## Department of Planning and Environment

Our ref: DOC22/342815

Your Ref: SSD-6236

### Subject: Request for Advice: Eastern Creek Energy from Waste Facility (SSD - 6236)

Figure 6. Survey area vegetation, habitat and fauna survey methodology map.

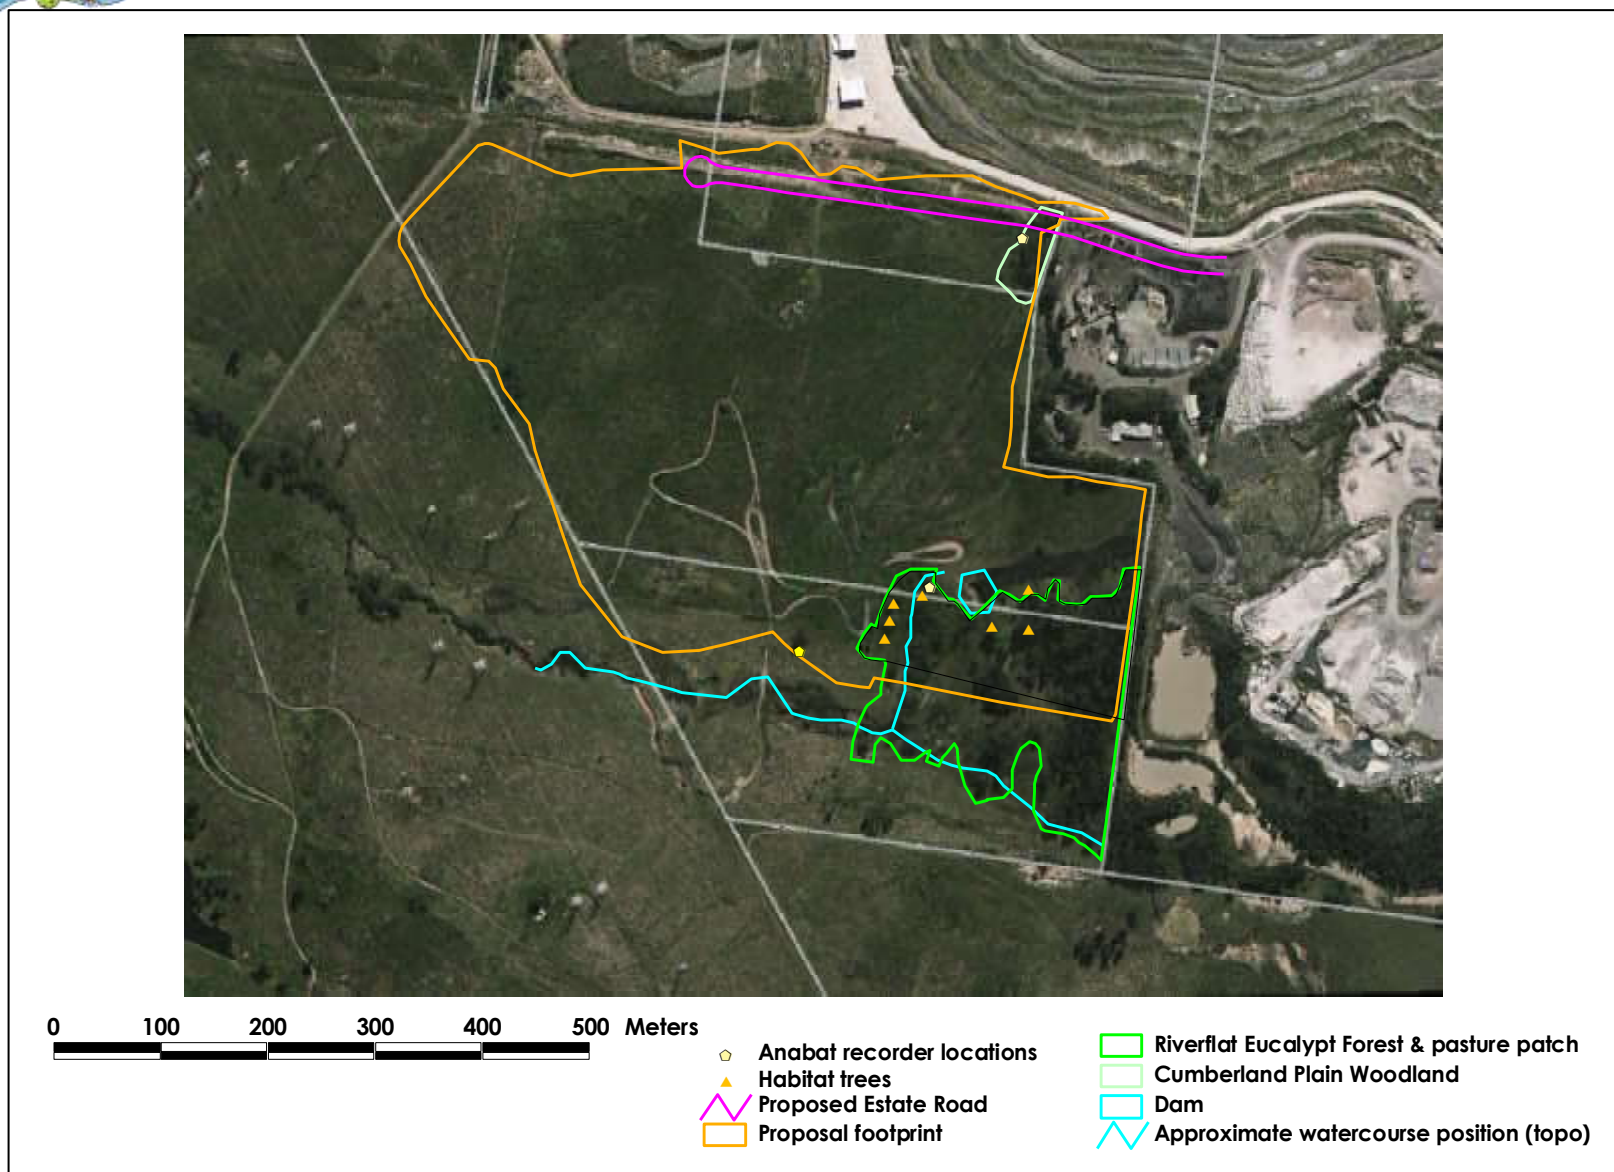
The vegetation mapping in the *Flora and fauna assessment report for Honeycomb Drive, Eastern Creek Lots 2 and 3, DP 1145808 Proposed Energy from Waste Facility, Eastern Creek (SSD 6236)* dated April 2015 (flora and fauna assessment) and the survey effort is not clear.

The survey and assessment methods that were employed are not considered current best practice. For example, BioNet identifies that surveys for the Large-eared Pied Bat should be undertaken in November, December, and January, compared to the April, May and February survey work conducted. The vegetation mapping also appears quite coarse, and the survey effort is not clear in the flora and fauna assessment report, in particular the assessment does not show where targeted flora surveys were carried out

EHG considers its previous biodiversity comments from 12 December 2018 (document reference: DOC18/27013) are not appropriate for the amended project and are no longer relevant. EHG recommends BAM 2020 is used, as required for the assessment of the Eastern Creek Energy from Waste Facility (SSD-8477614), to assess the biodiversity values of the site and the proposed impacts, along with any offset requirements.
